Question

Kippure Lodge and Holiday Village,
Kippure Estate, Manor Kilbride,
Blessington, County Wicklow.

Wicklow County Council

EX53/2024

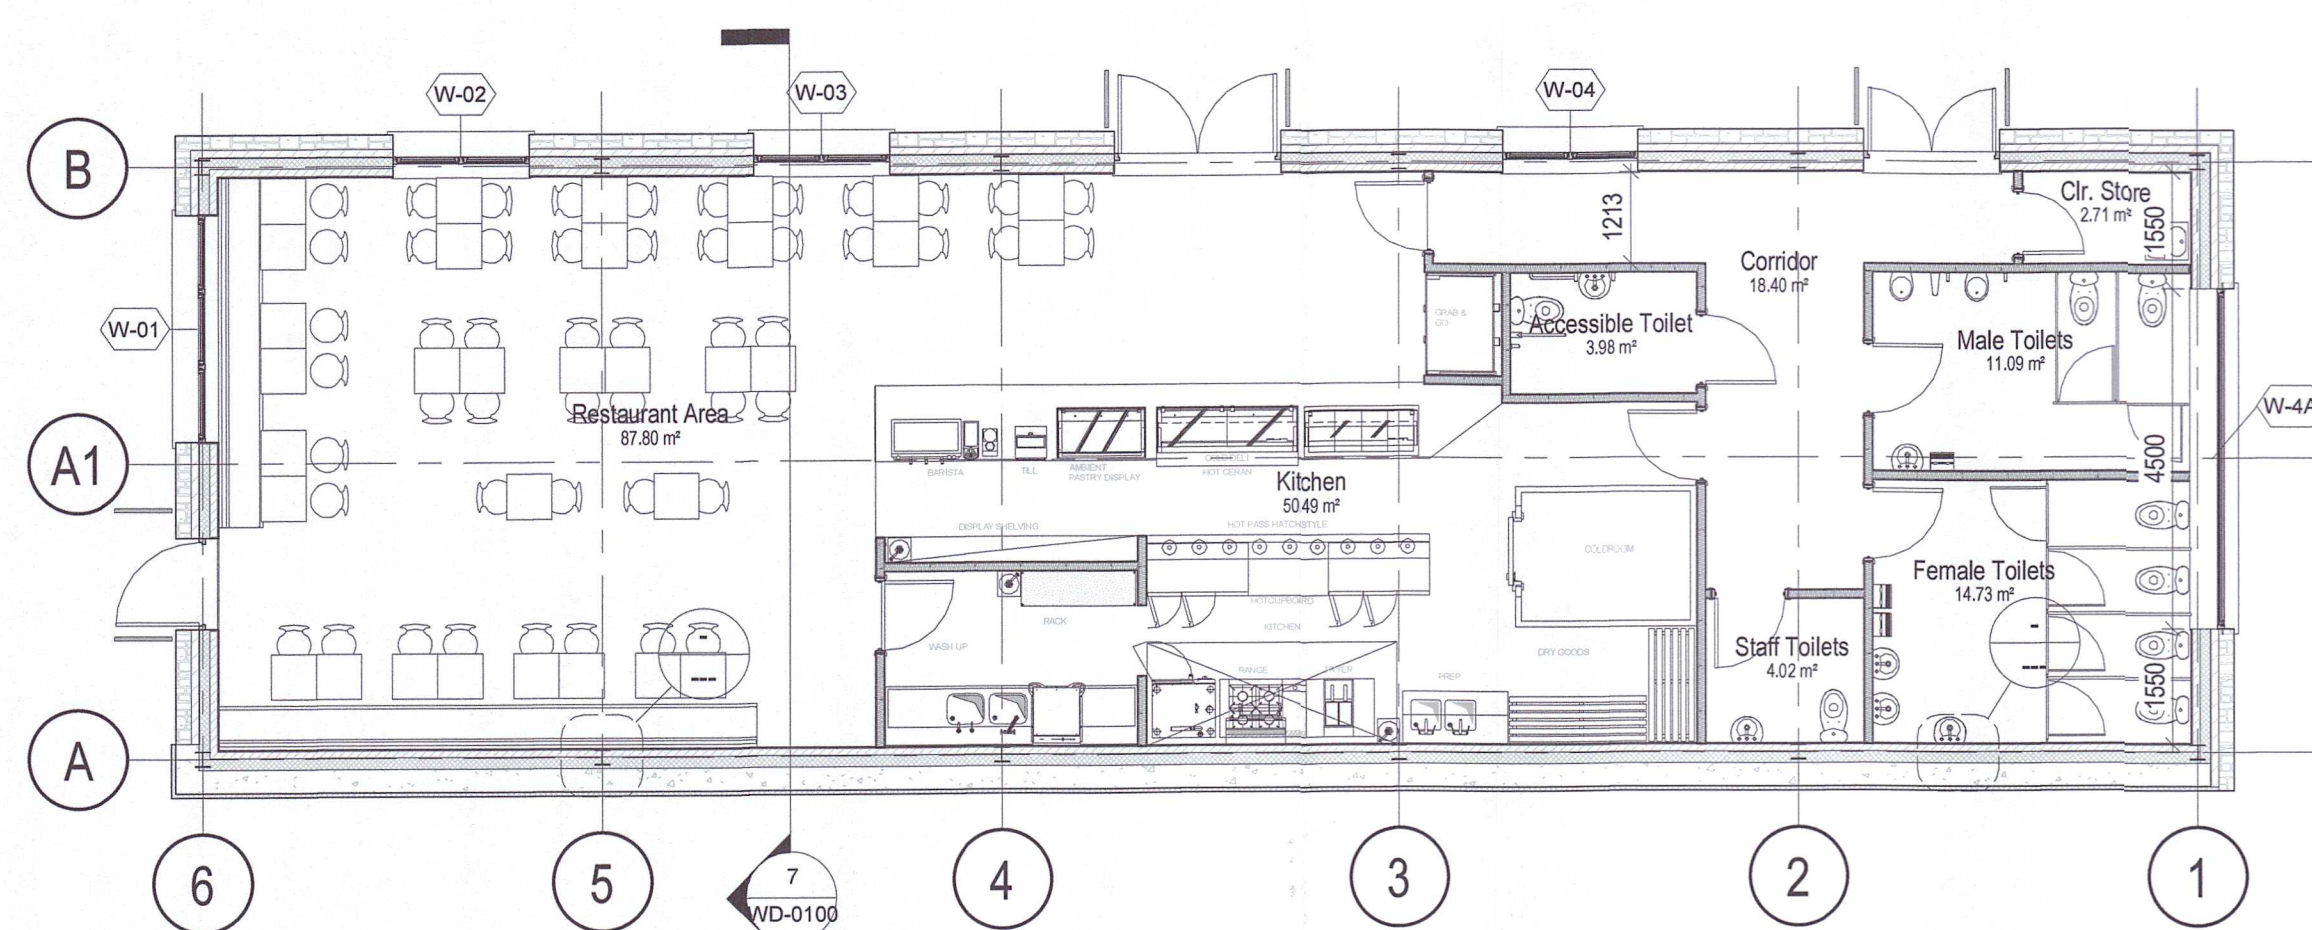
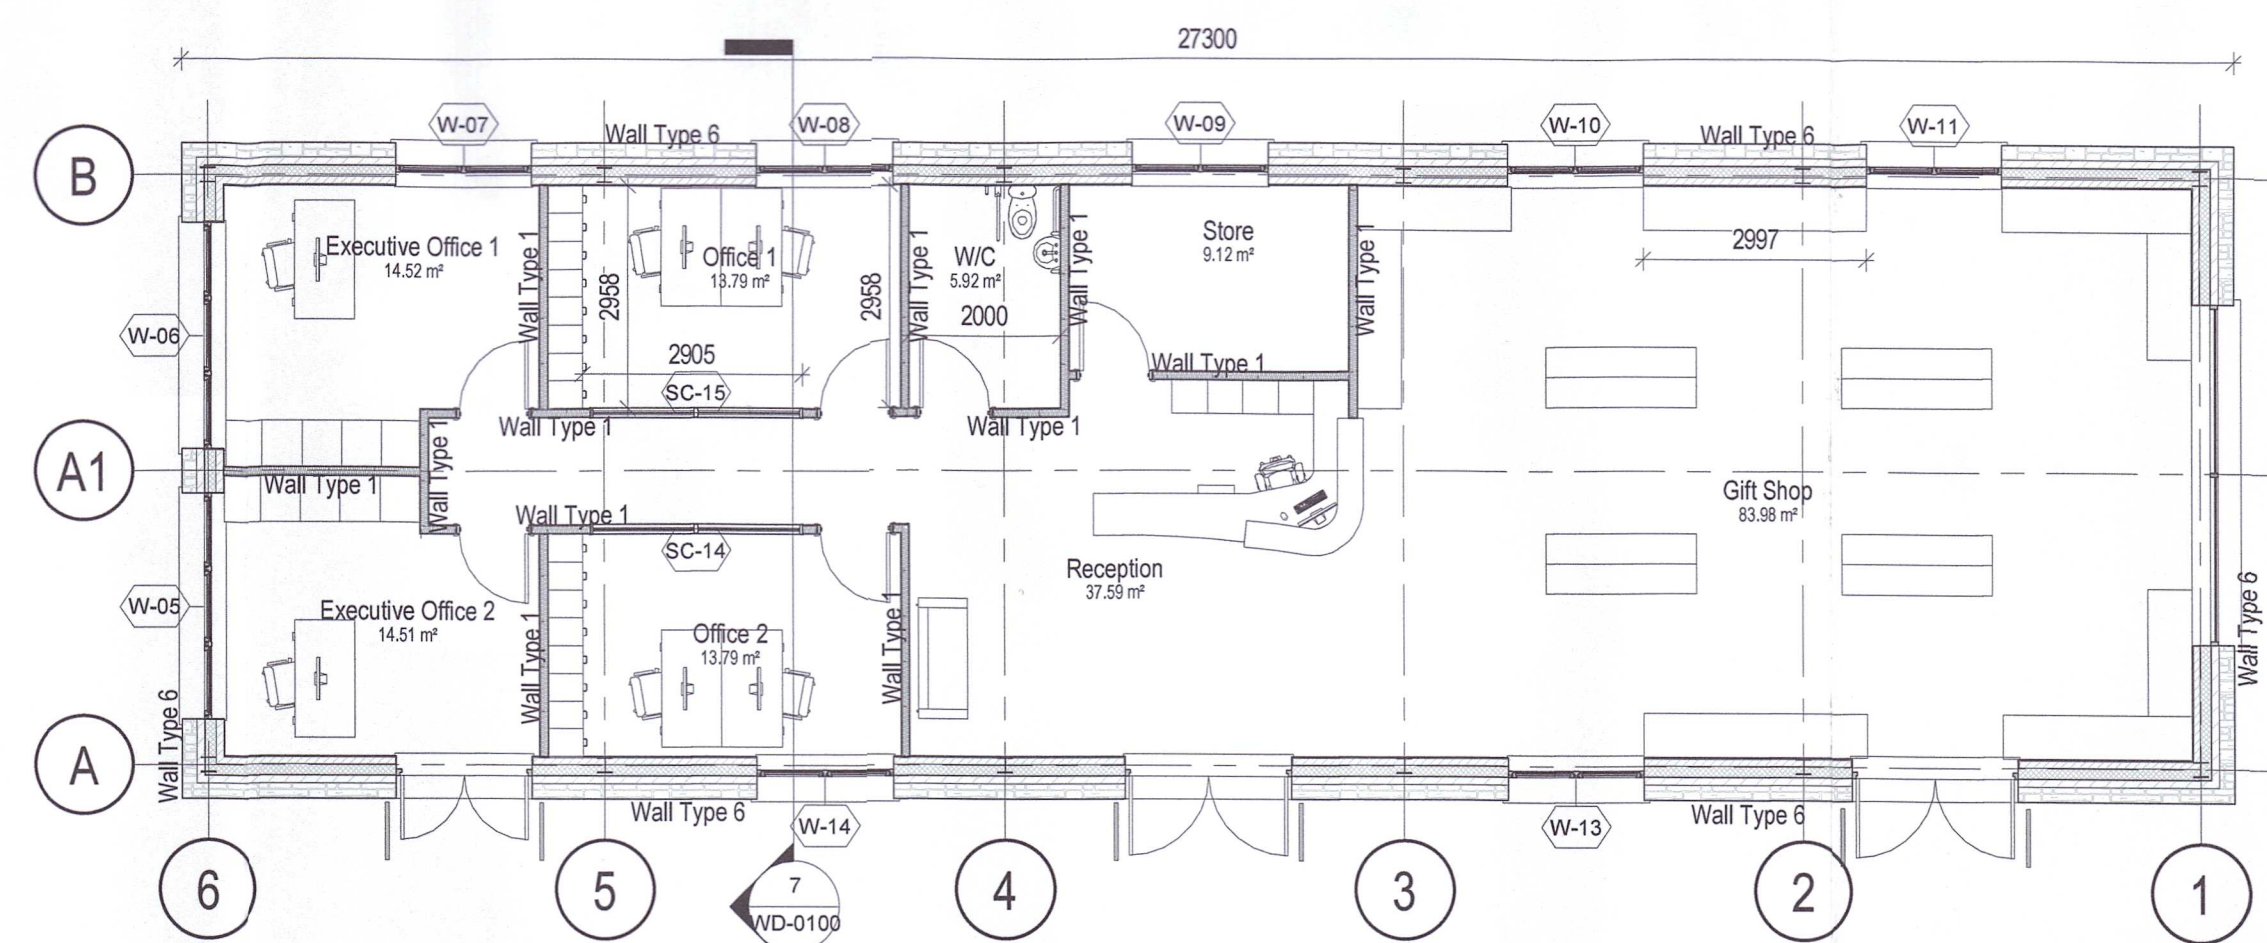
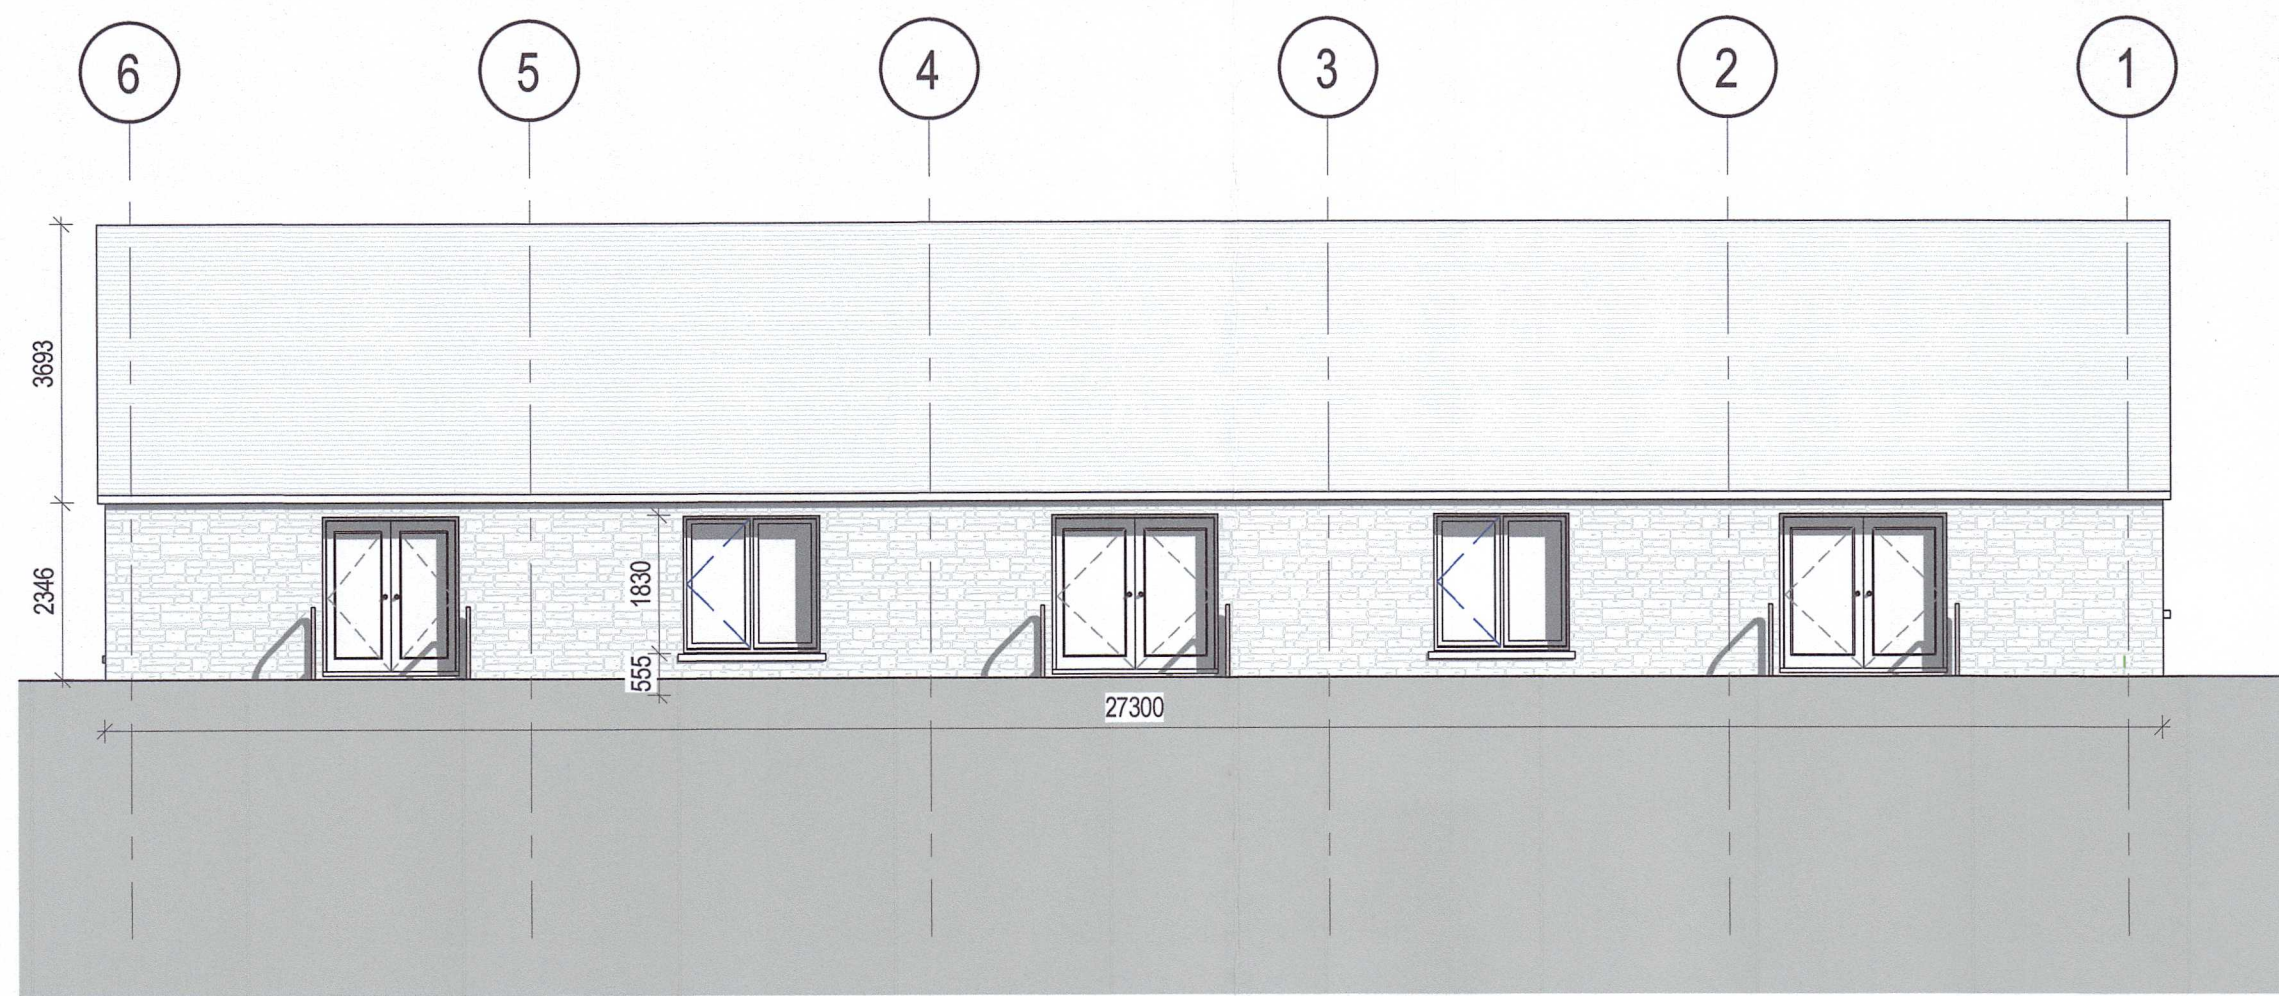
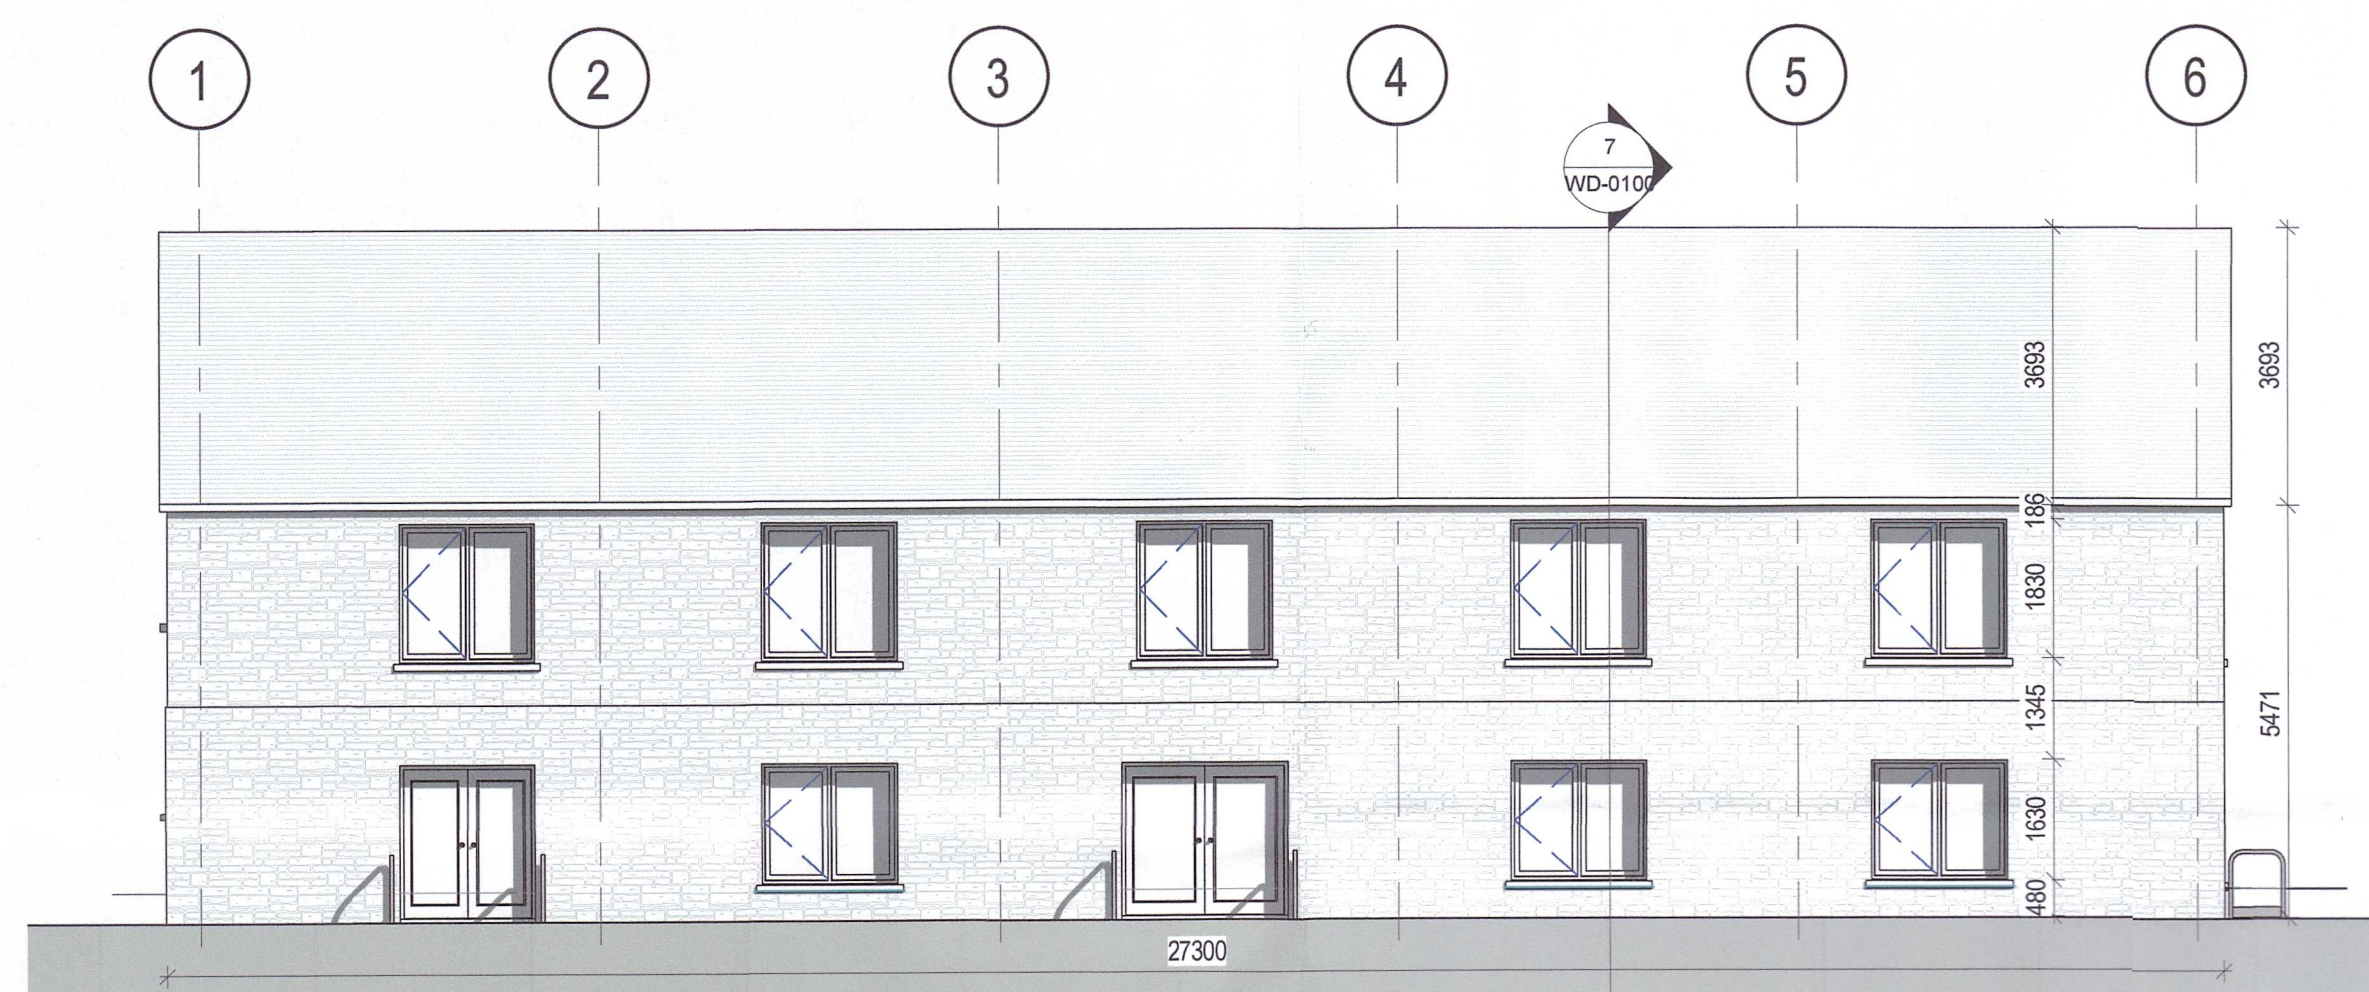
This building was constructed in c. 1830 and predates the Planning Acts and modern planning law. The structure has been upgraded and renovated as exempted development under Section 4(1)(h) of the PDA. Permission was also granted under Reg. Ref.05/2792 for the refurbishment of the Belfry Building and its use as a backup facility for outdoor facilities.

The structure has been extended and altered by reference to changes in height, length and width. The nature of the works would not comprise maintenance, improvement or other alteration and result in the structure being materially different to the former structure. The works have significantly altered the external appearance of the structure so that it is inconsistent with the character of the structure.

There are no exemptions under the PDR.

There are no other exemptions available for this structure. Therefore, it is development and is not exempted development.
